CITY OF ALBUQUERQUE

February 10, 2022

**RE: Albuquerque ER & Hospital
4315 Wyoming Blvd NE
Grading and Drainage Plan
Engineer's Stamp Date: 1/27/22
Hydrology File: G19D004D**

**GR-1**

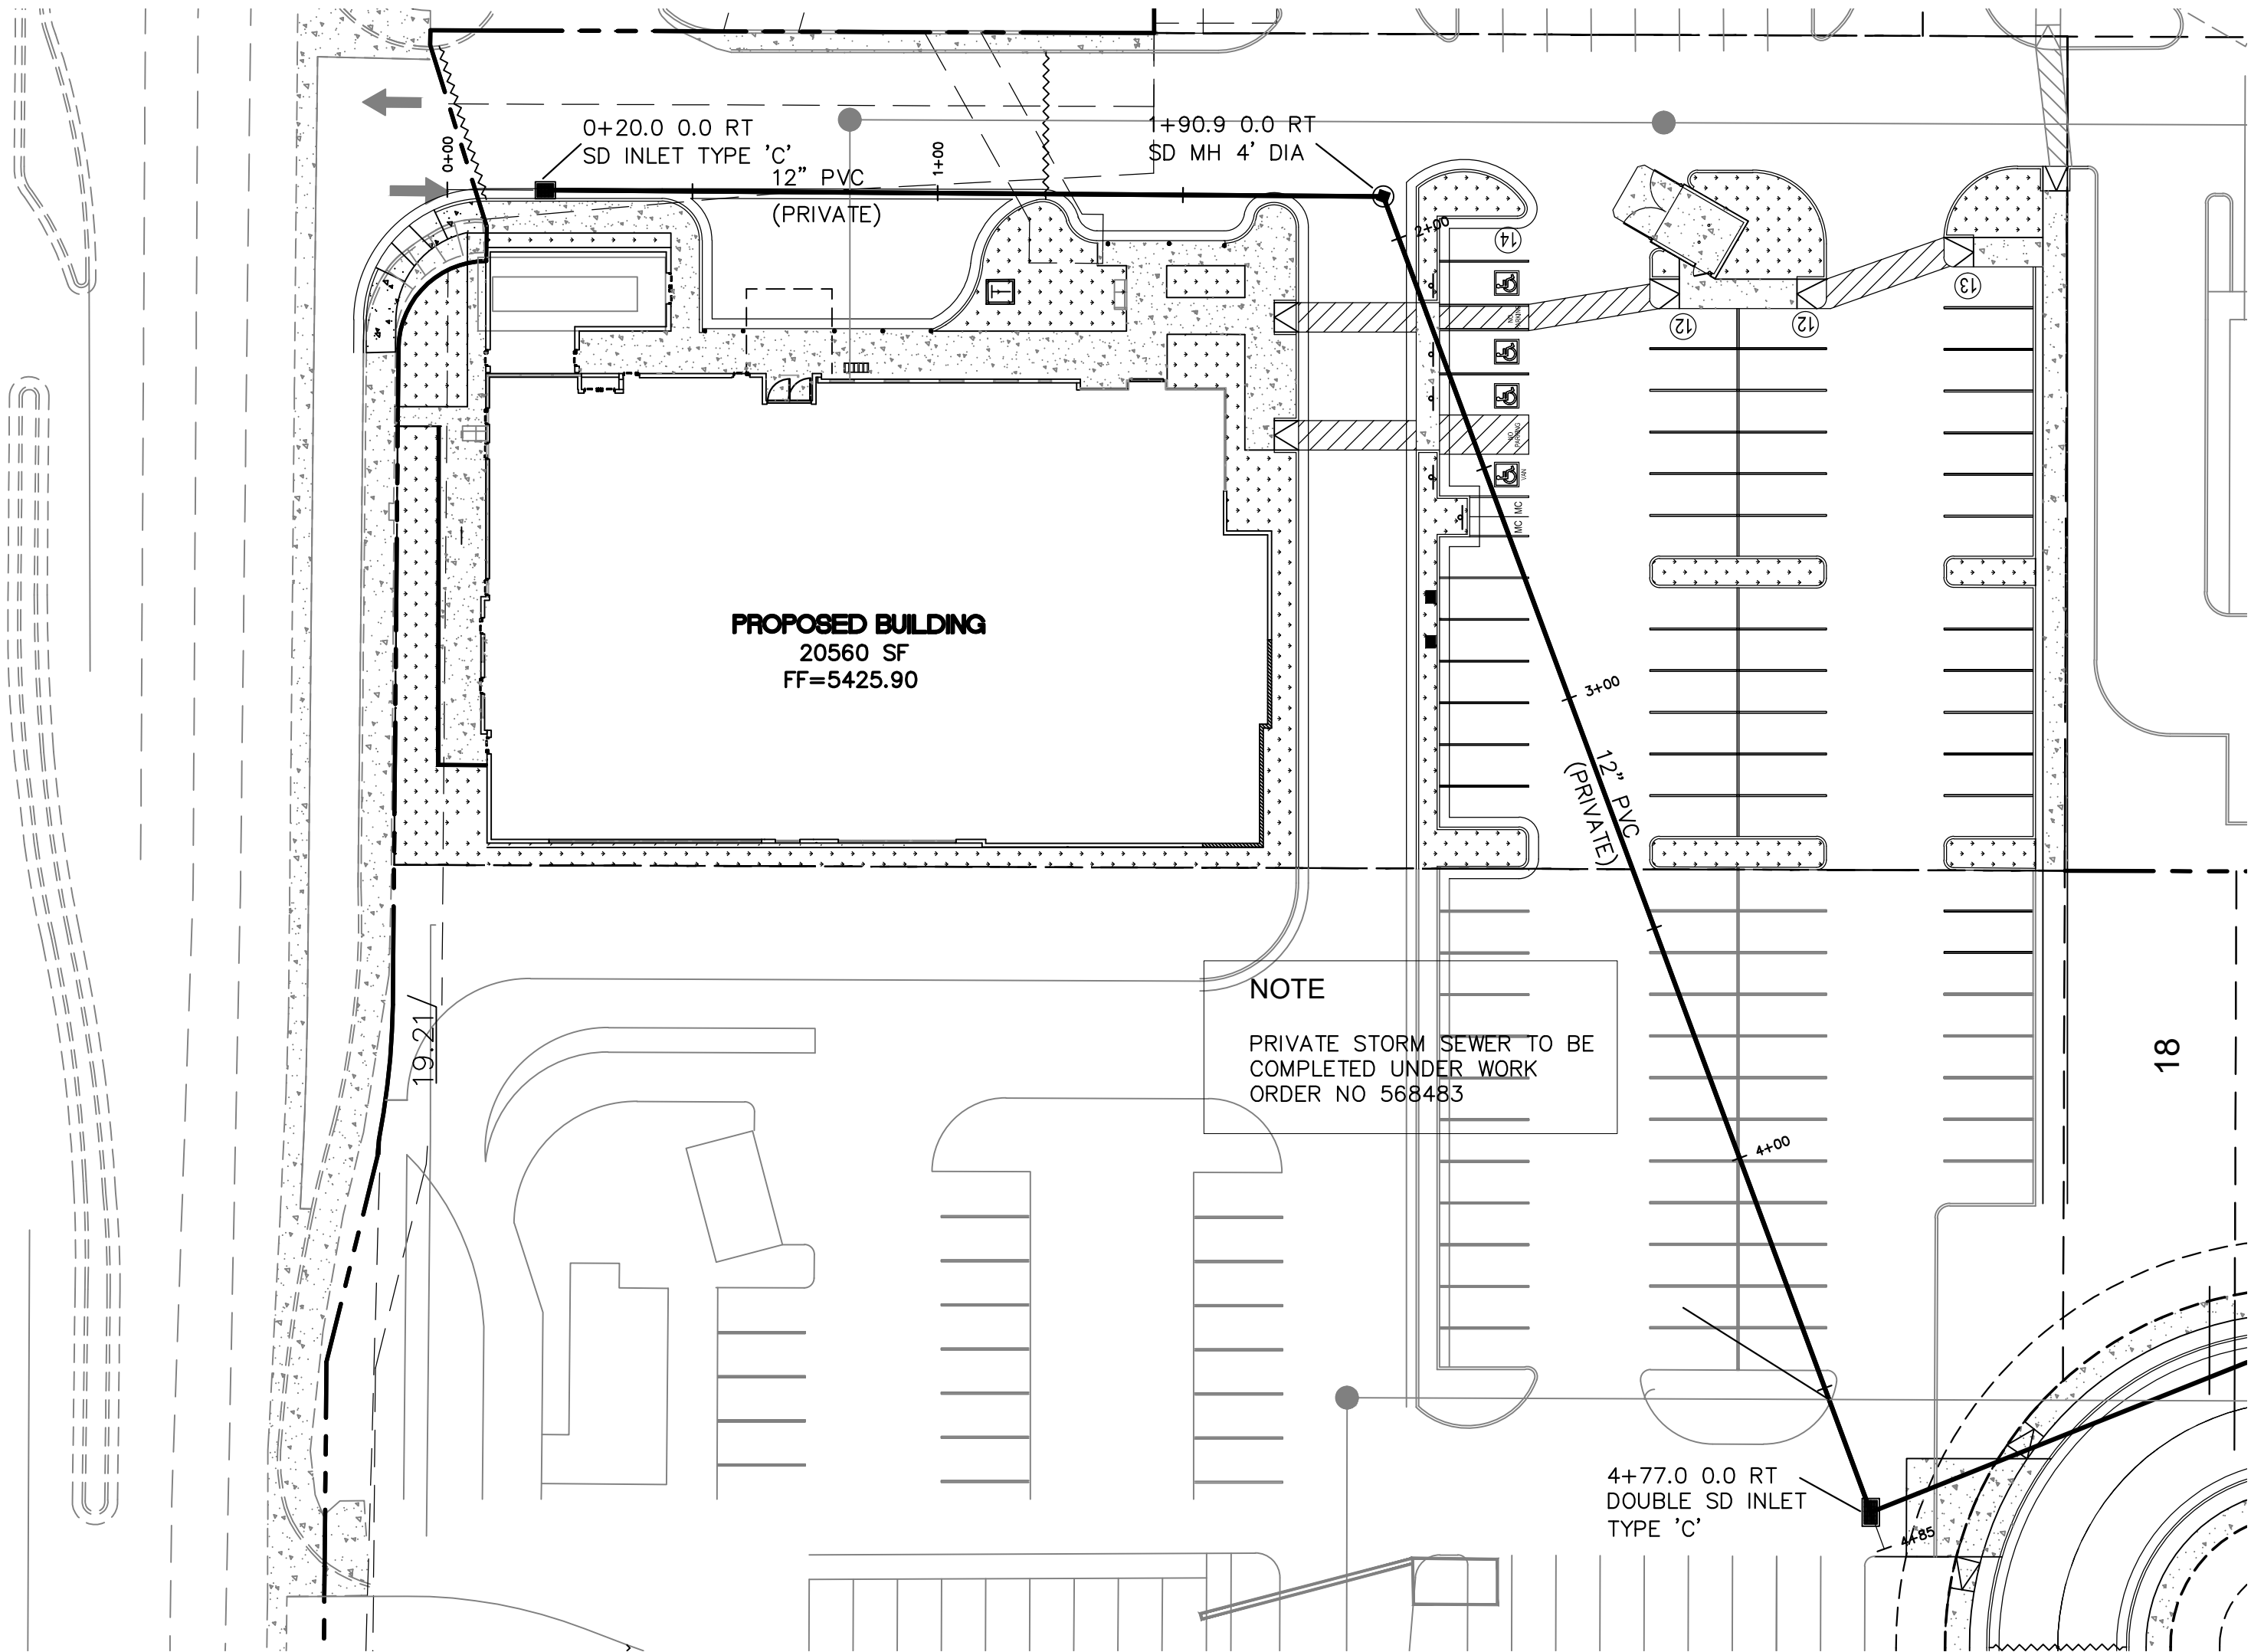
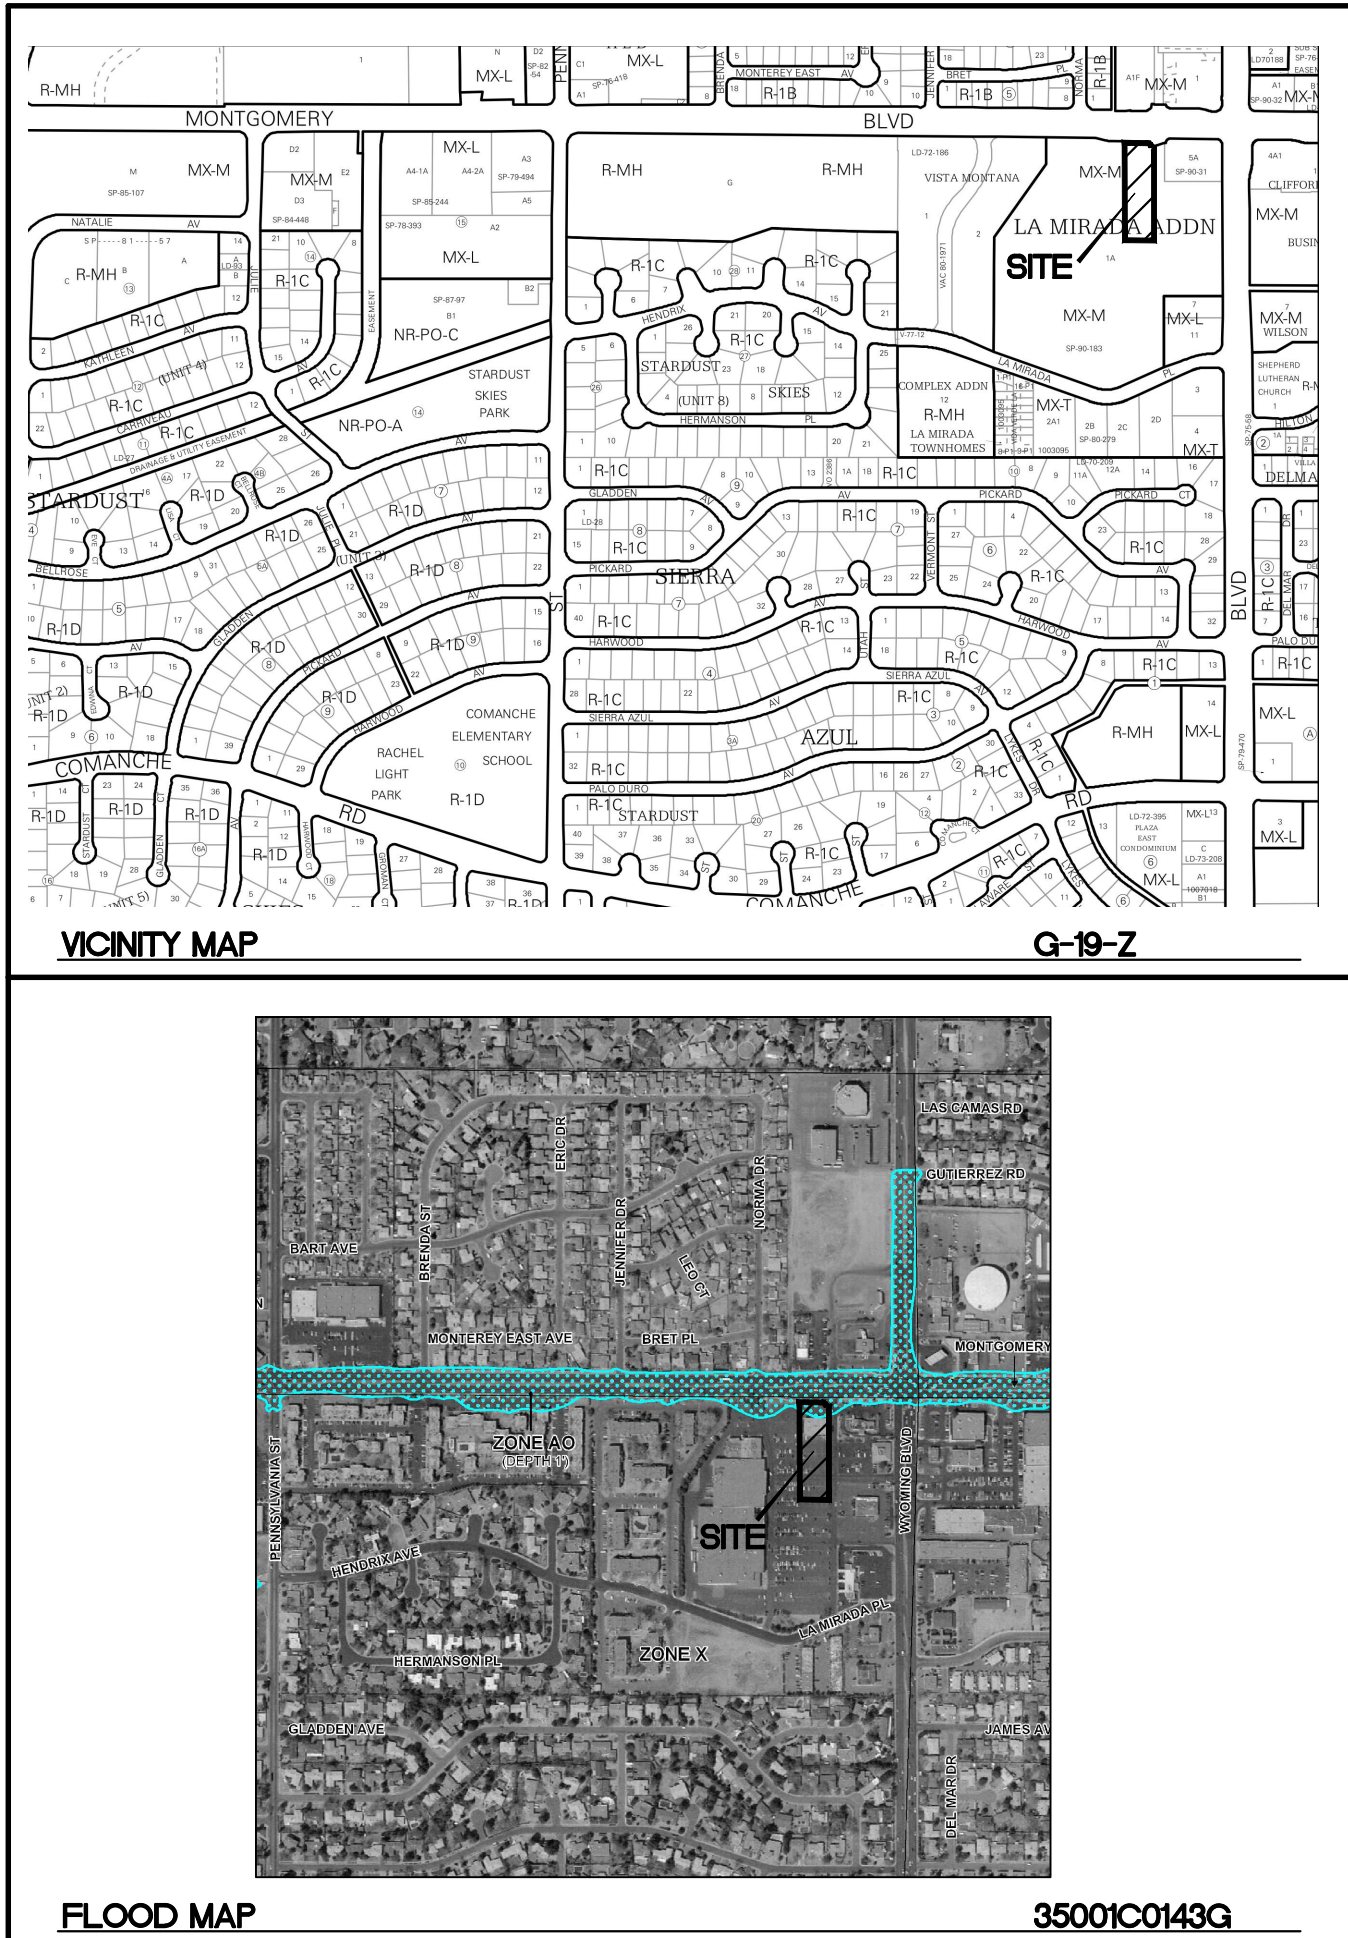
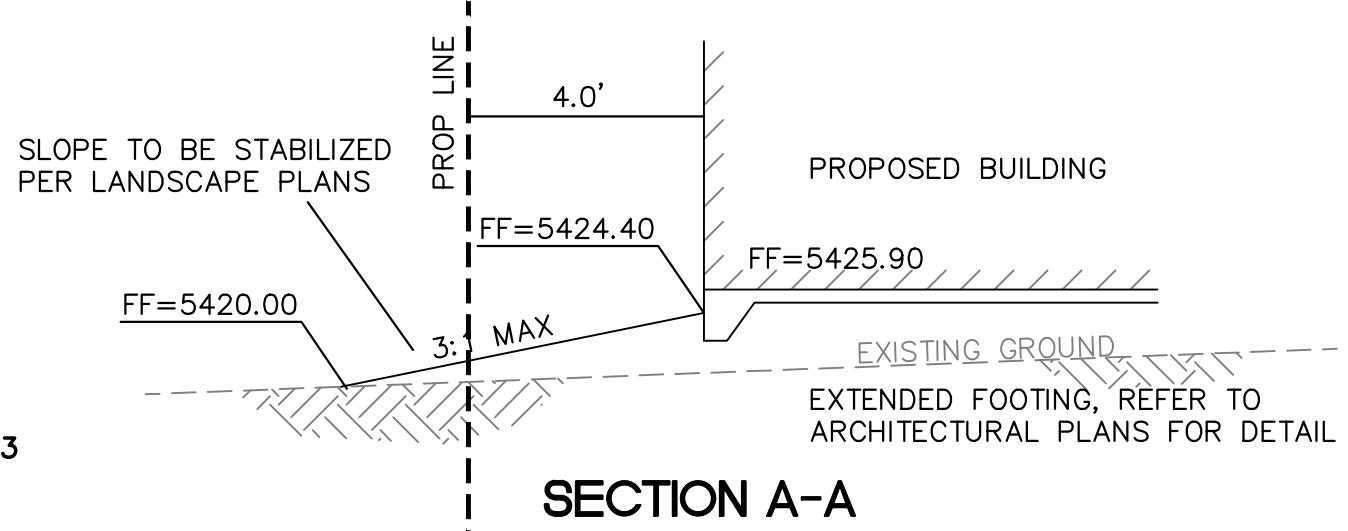
SHEET GR-1

1. Please provide a detail of the CMU perimeter wall.
2. Please show the property line in detail A-A and ensure this slope does not affect future plans of adjacent property. Also, please show the elevation where the proposed grade and 3:1 max slope meet.

3. Ensure the proposed construction on this plan are delineated from the work order and reference the work order.
 - a. Show spot elevations and details as provided in the work order so grades are known and can be matched up on both plans.

4. Ensure that if the work order will be completed first, the owner of this development will need to sawcut the existing pavement to install curb and gutter and the curb and gutter appropriately. If this is not the plan, please provide a phasing plan how this will be completed.

- a. Is this the same contractor or will there be different contractors?
 - b. The information from the work order for the work being completed in Montgomery is important because as-is, it is unclear how the site will tie into adjacent grades by other projects and existing infrastructure.

5. Provide grades on adjacent sites to detail how things will tie in.
6. In the provided G&D, the storm drain shows a dead-end inlet. Please clean this up and show where this will go ultimately. Should be existing by the time this is constructed?

7. Please show proposed contours.
 8. Please show water block as detailed in the work order at entrance to ensure no flow goes to Montgomery. It is still unclear how flow is being maintained within the site without this information.
 9. Overall, please ensure constructability. As the G&D is presented, I do not feel a contractor can take this and understand what he is constructing especially that the driveway is being constructed by work order.
 10. Call out amount of offsite drainage and state it will be maintained on the G&D.
 11. Include the interim grading plan for reference only.
- Previous comments: not addressed
12. Please provide results from DPM Part 6-2(A) regarding what zone the property lies in and associated rainfall and calculations. No information was included to specify existing or proposed flows.

14. Please add a note under Grading Notes. "Side slopes need to be stabilized with Native Grass Seed (per City Spec 1012) with Aggregate Mulch or equal (Must satisfy the "Final Stabilization criteria" CGP 2.2.14.b.)".
15. Provide a section of the stem wall. (Extended footing or stem wall – please provide detail)
16. What are these? (still not labeled)

17. Show any shared easements. (not provided – call out at least)
